From: [Dave Aube](#)
To: [Webb, Robert L.](#)
Cc: [Shannon VanDusen](#); [Emily Brudenell](#)
Subject: Re: 1300 Britt
Date: Wednesday, June 7, 2023 6:35:14 PM
Attachments: [image013.png](#)
[image014.png](#)
[image015.png](#)
[image016.png](#)
[image017.png](#)
[image.png](#)

1300 Britt

I had a couple questions on the AA submittal.

SHEET TITLE  
PROPOSED SITE DEVELOPMENT PLAN FOR BUILDING PERMIT

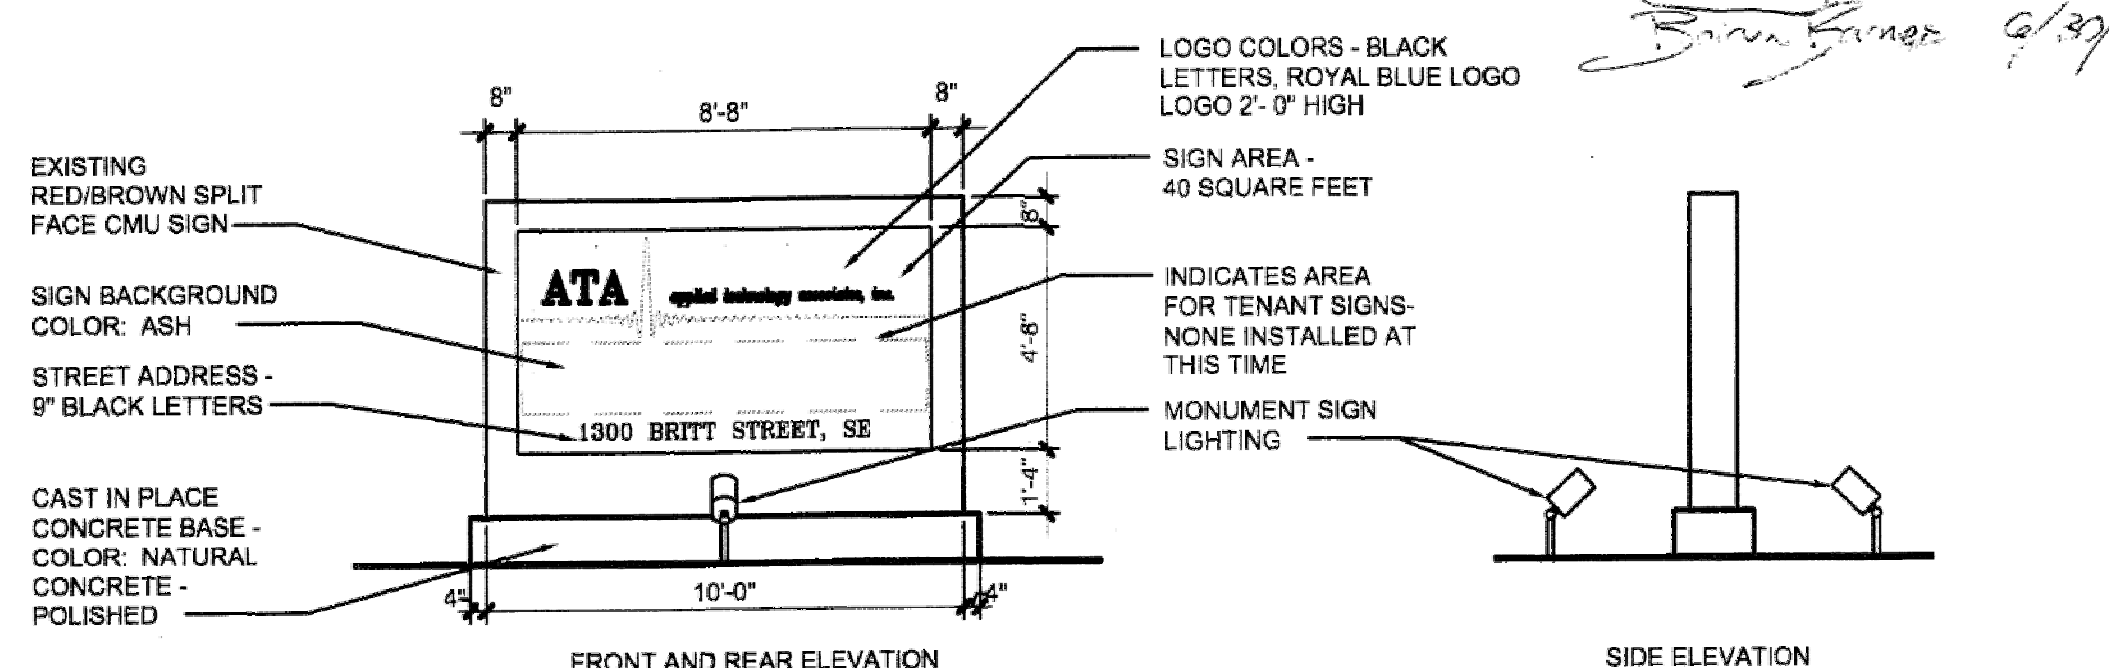
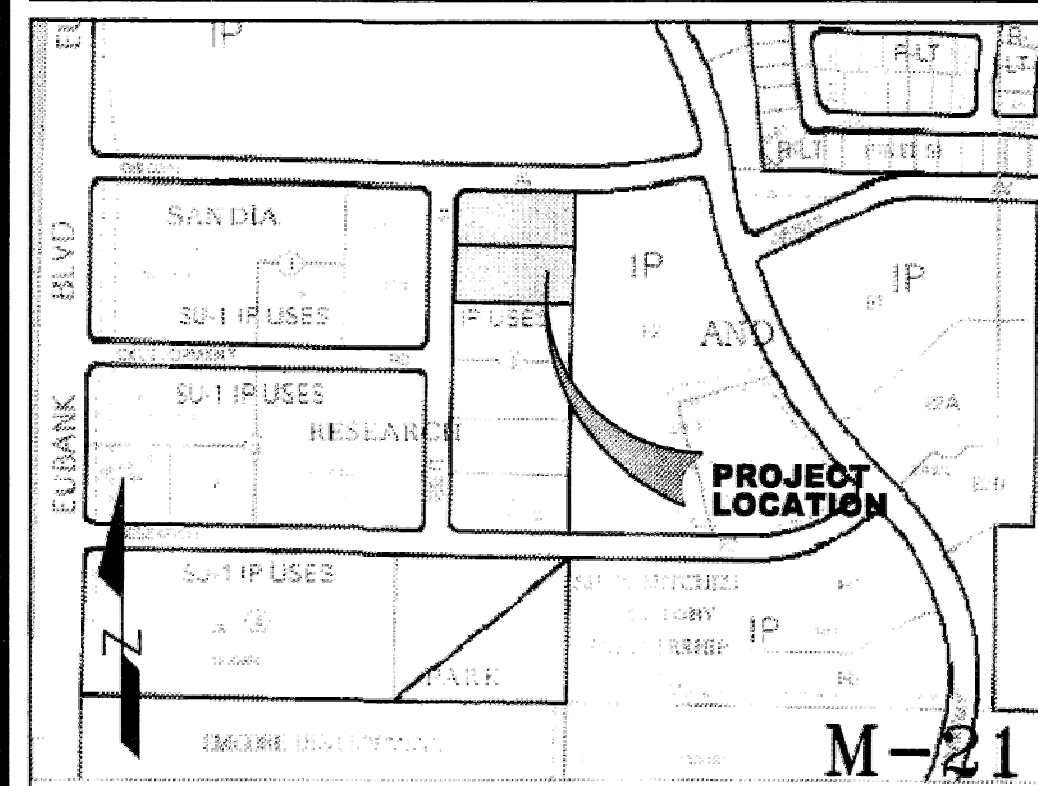
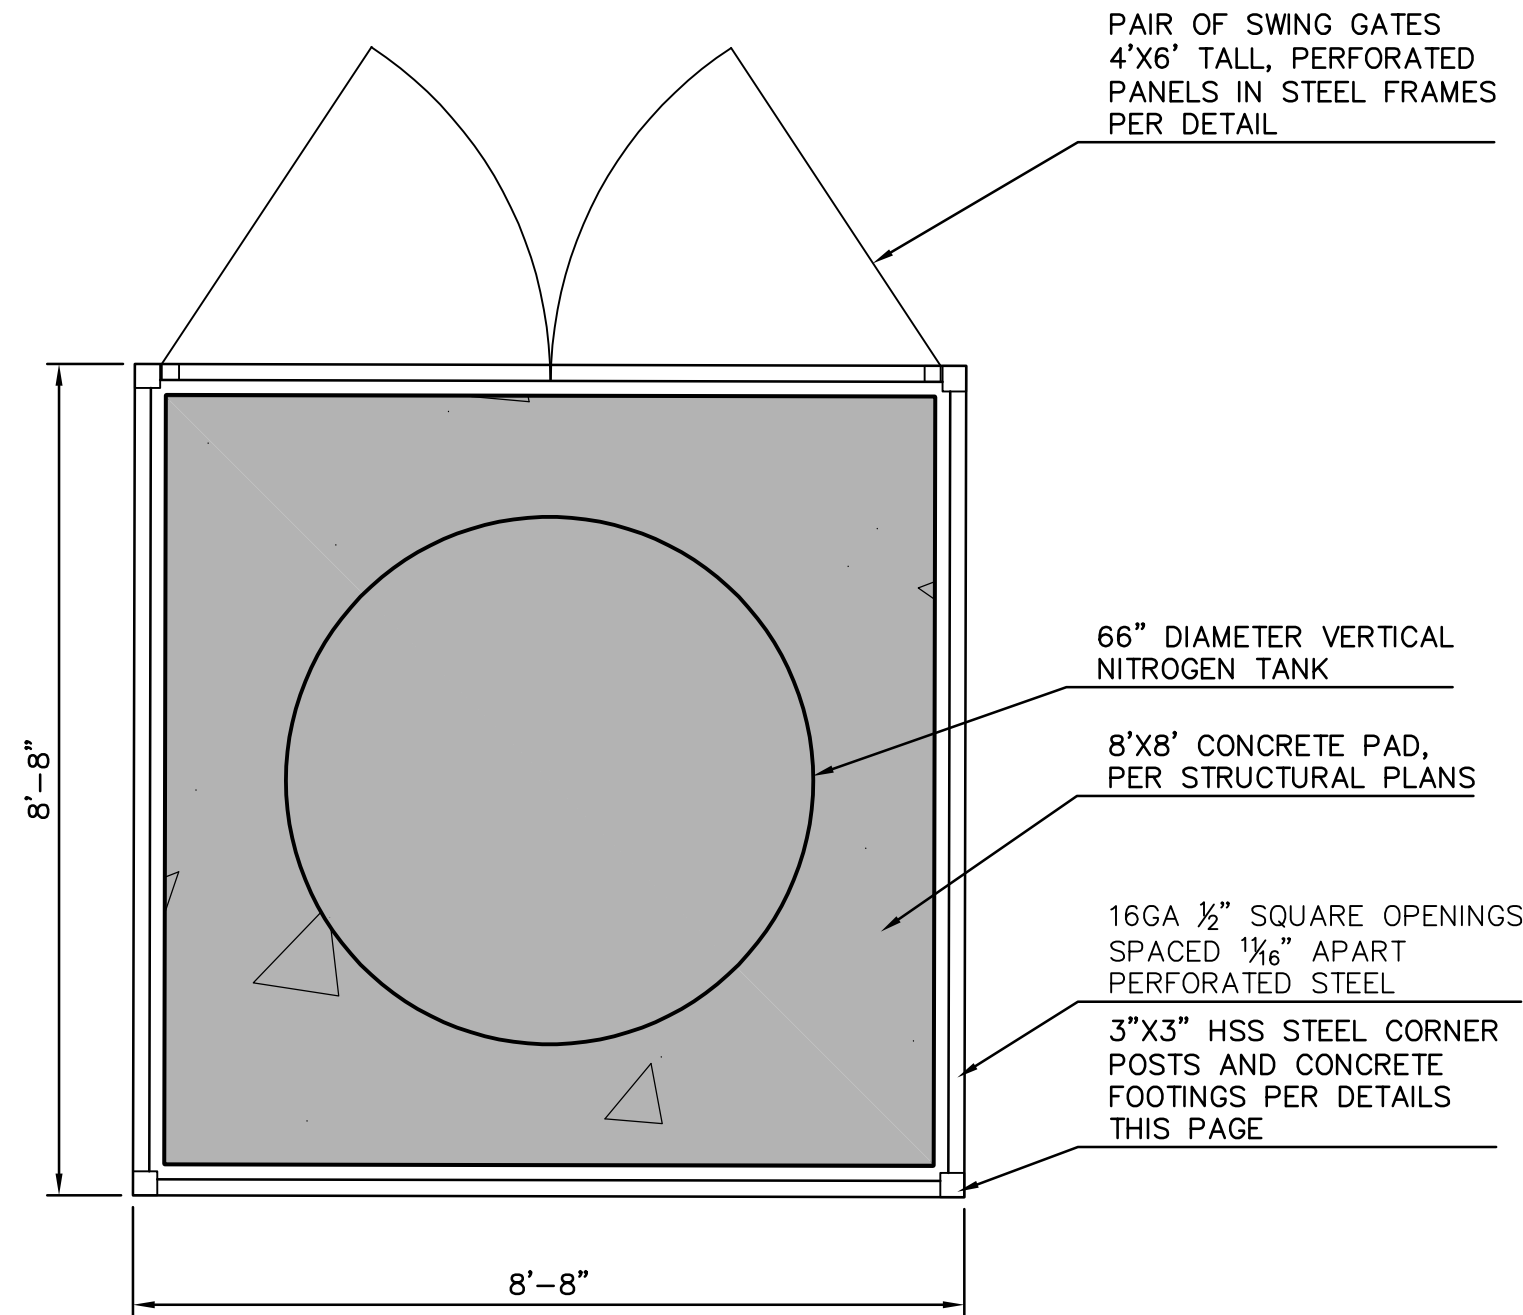
*Parking is being reduced

Is it meeting the standards of the original plan and/or the IDO?

Calculations?

*Landscaping is being reduced.

Will it still meeting the standards of the original plan?

*Parking is being reduced

Will it still meeting the standards of the original plan?

The parking is not being reduced. We are converting 7 standard size stalls to compact along the proposed building addition. They will be the only compact parking on site. We are still maintaining the 101 provided parking stalls.

As far as the Landscaping, we are proposing a reduction of 735 sf. We are required a total of 4011 sf, and will still have 8,435 sf on site.

As far as the parking, we are simply converting the standard parking stalls (8.5x18) to compact parking stalls (8.5x15) to give a little more room for the building addition.

The total number of compact spaces on the site will be 7 out of the required and provided 101.
